DEPARTMENT OF PUBLIC WORKS

MEMORANDUM

TO: Mackenzie Moynihan, CDS
FROM: Christina Wollman, Planner II *CW*
DATE: August 29, 2008
SUBJECT: Request for More Information
Darrow Plat LP-08-25

DARROW PLAT
PTN OF THE N 1/2 SEC. 06, T.20N., R.18E., W.M.
Kititas County, Washington

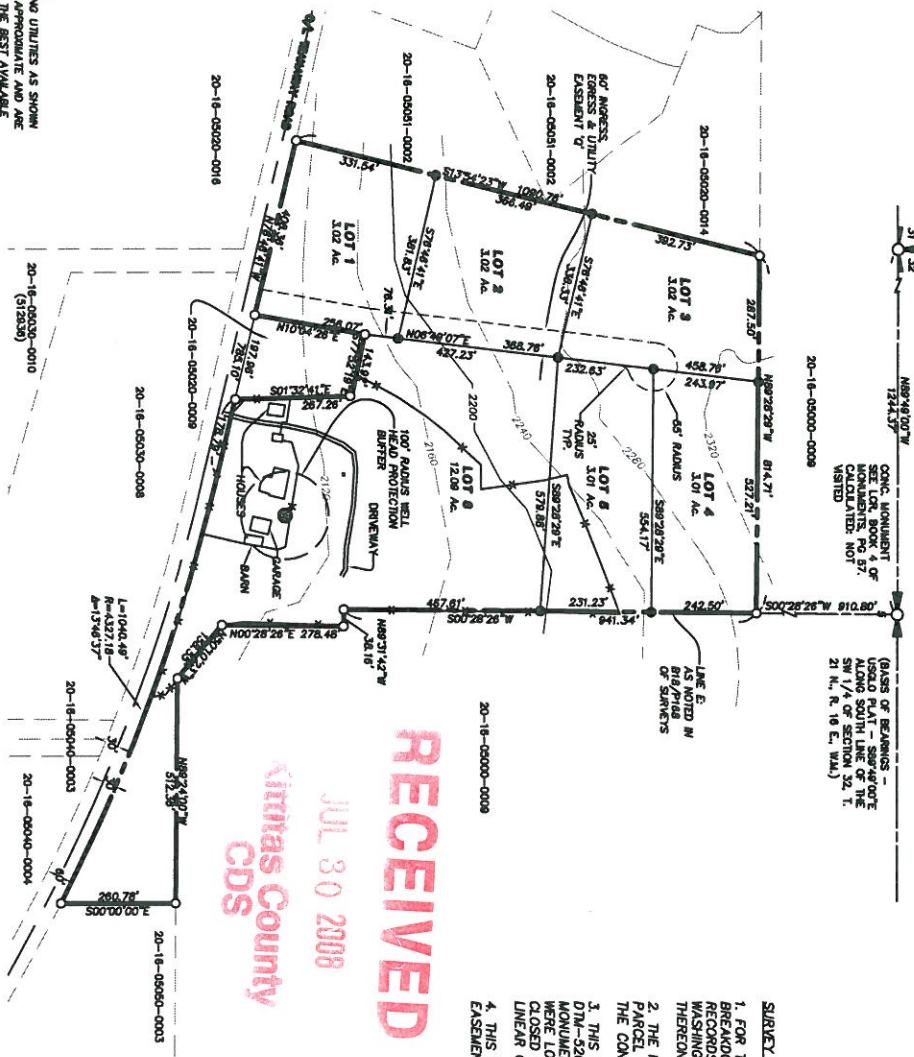
On August 25th I spoke with Walter Darrow who told me that the access to Lots 1-5 would be shared with the Teanaway Store access. Even with this information, I would like an illustration showing where the accesses to the Teanaway Store are in relation to the existing and/or proposed accesses.
